Our Ref: BR/128/20/DOC

Approval of details reserved by condition imposed under BR/219/18/PL for condition 4-surface water drainage; 5-colour schedule of materials & finishes, 6-dustbin enclosures details; 7-electrical vehicle charging points, 8-incorporation of decentralised, renewable, low carbon energy supply system, 9-vehicular access details & 11-cycle parking space details.

9 Westloats Lane Bognor Regis PO21 5JZ

Sheet
 1A

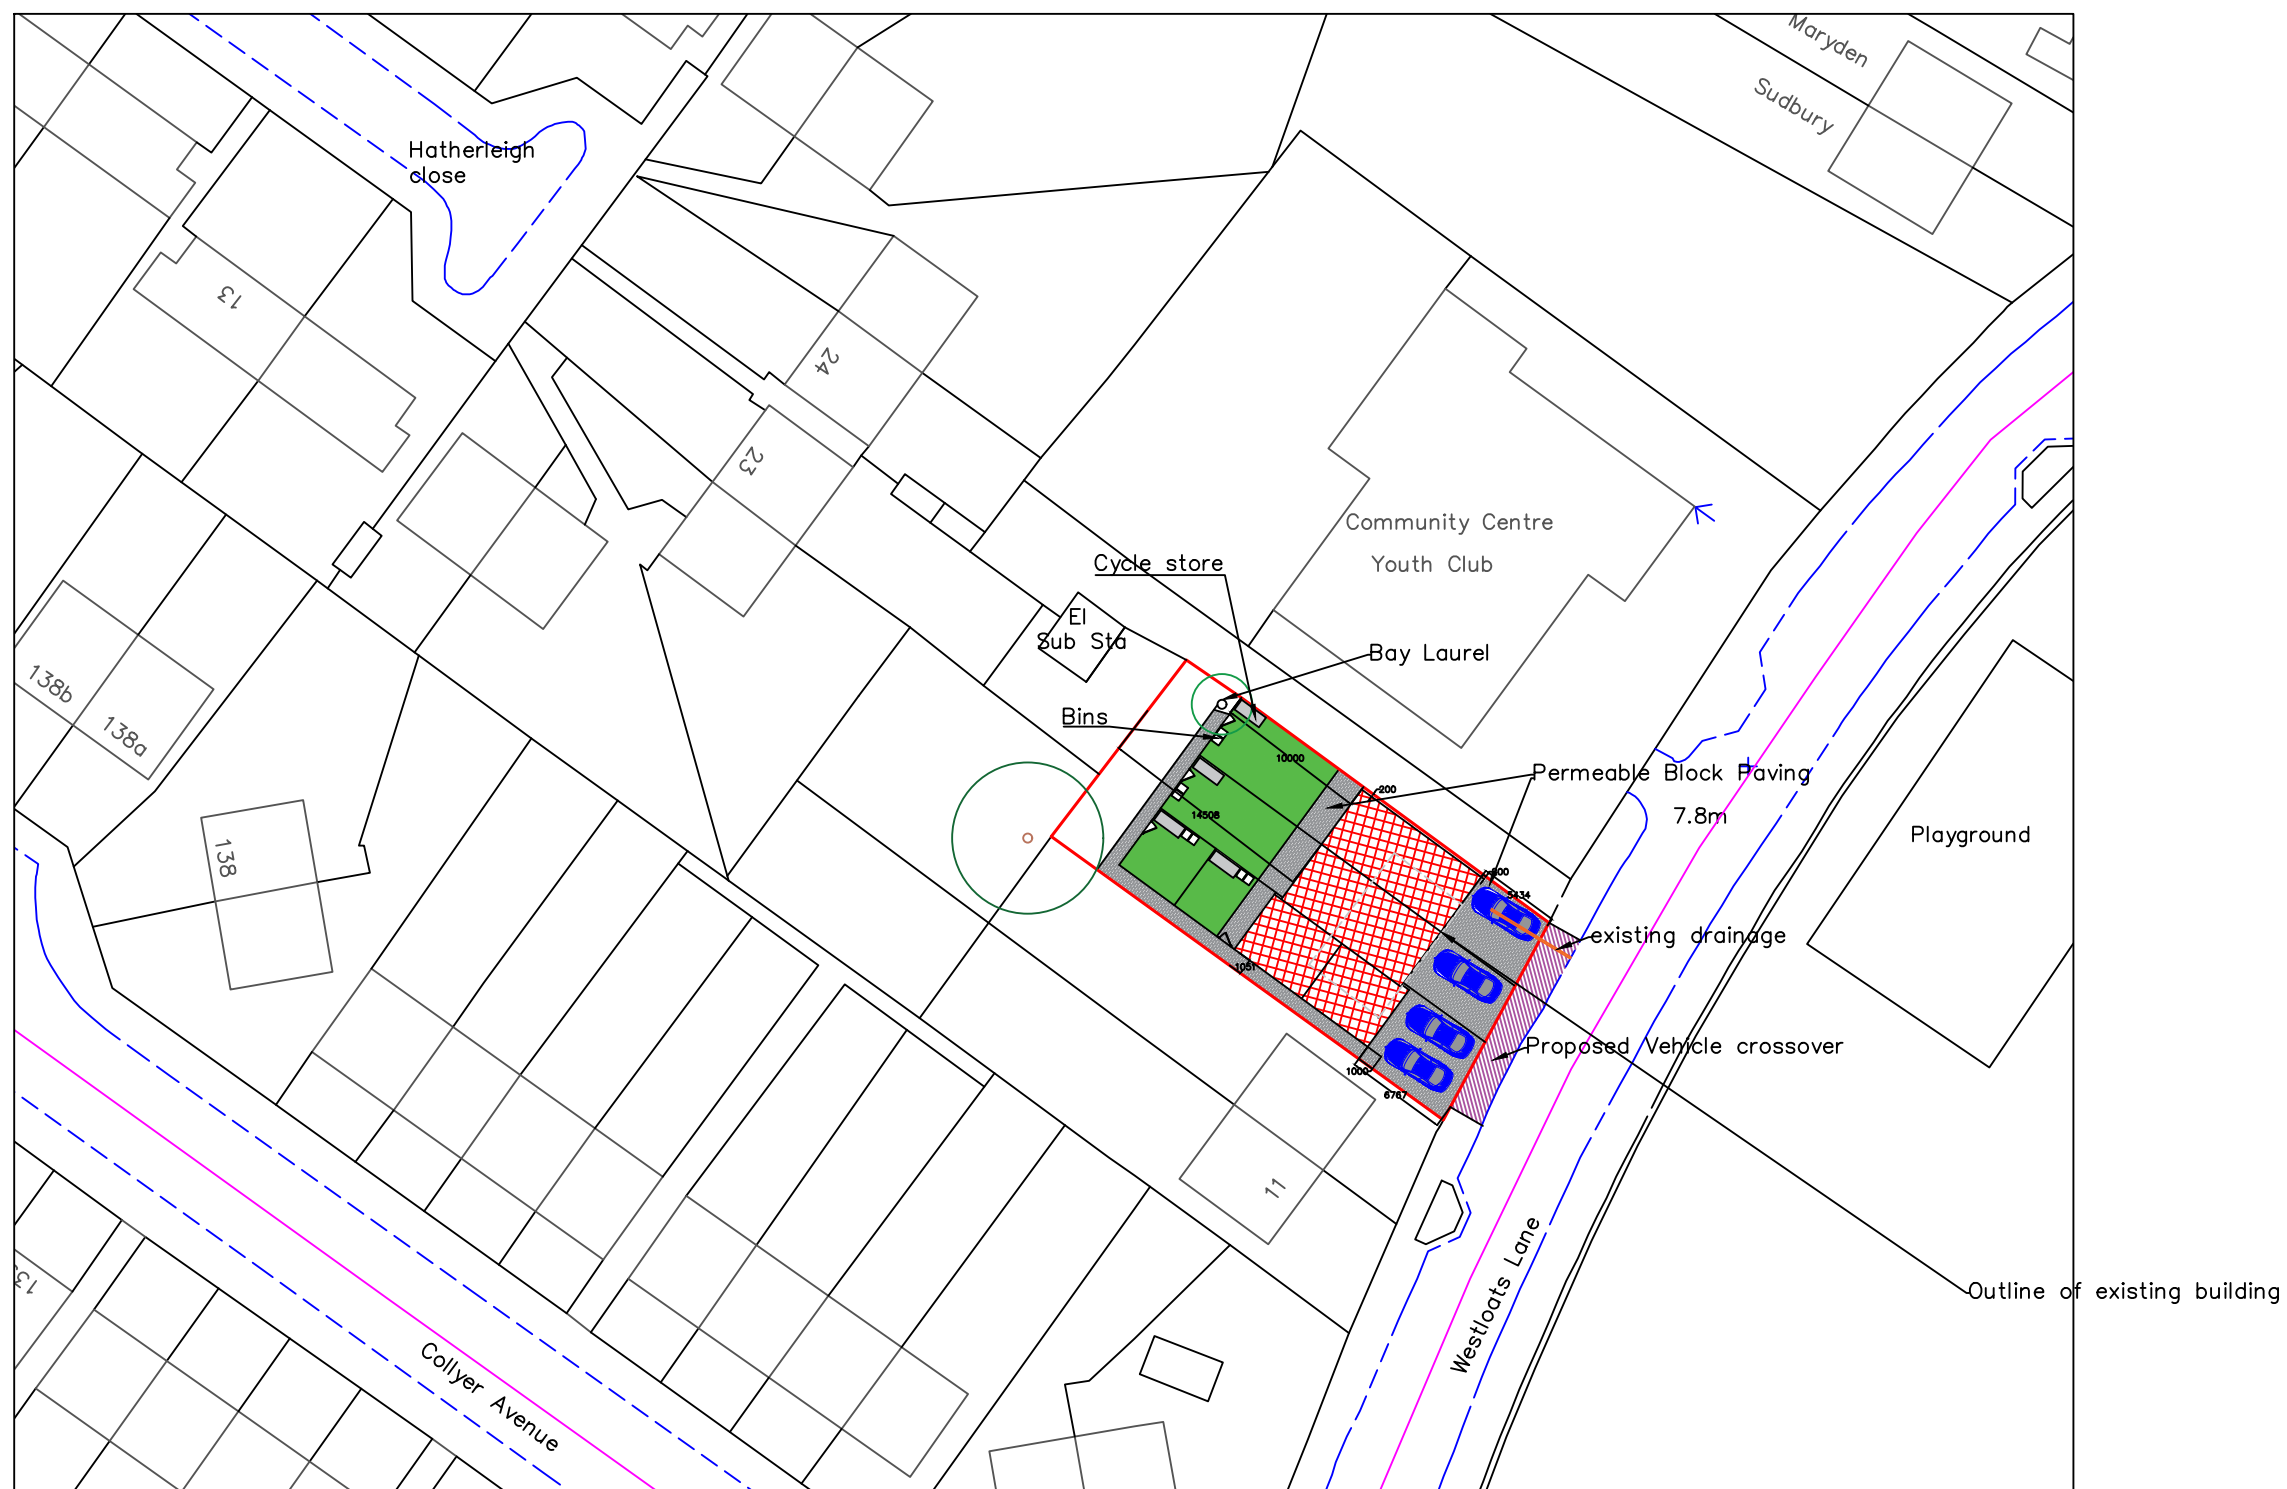
The submitted site plan (Sheet 1A) in respect of cycle storage indicates provision of a secure and covered cycle shed for each dwelling. Whilst difficult to determine from the plans, it appears that each shed is suitable to accommodate two bikes. The LHA is satisfied with the details provided for this condition.

The condition is therefore fully discharged insofar as the submission of site plan relates and on the understanding that the cycle storage sheds will be permanently retained.
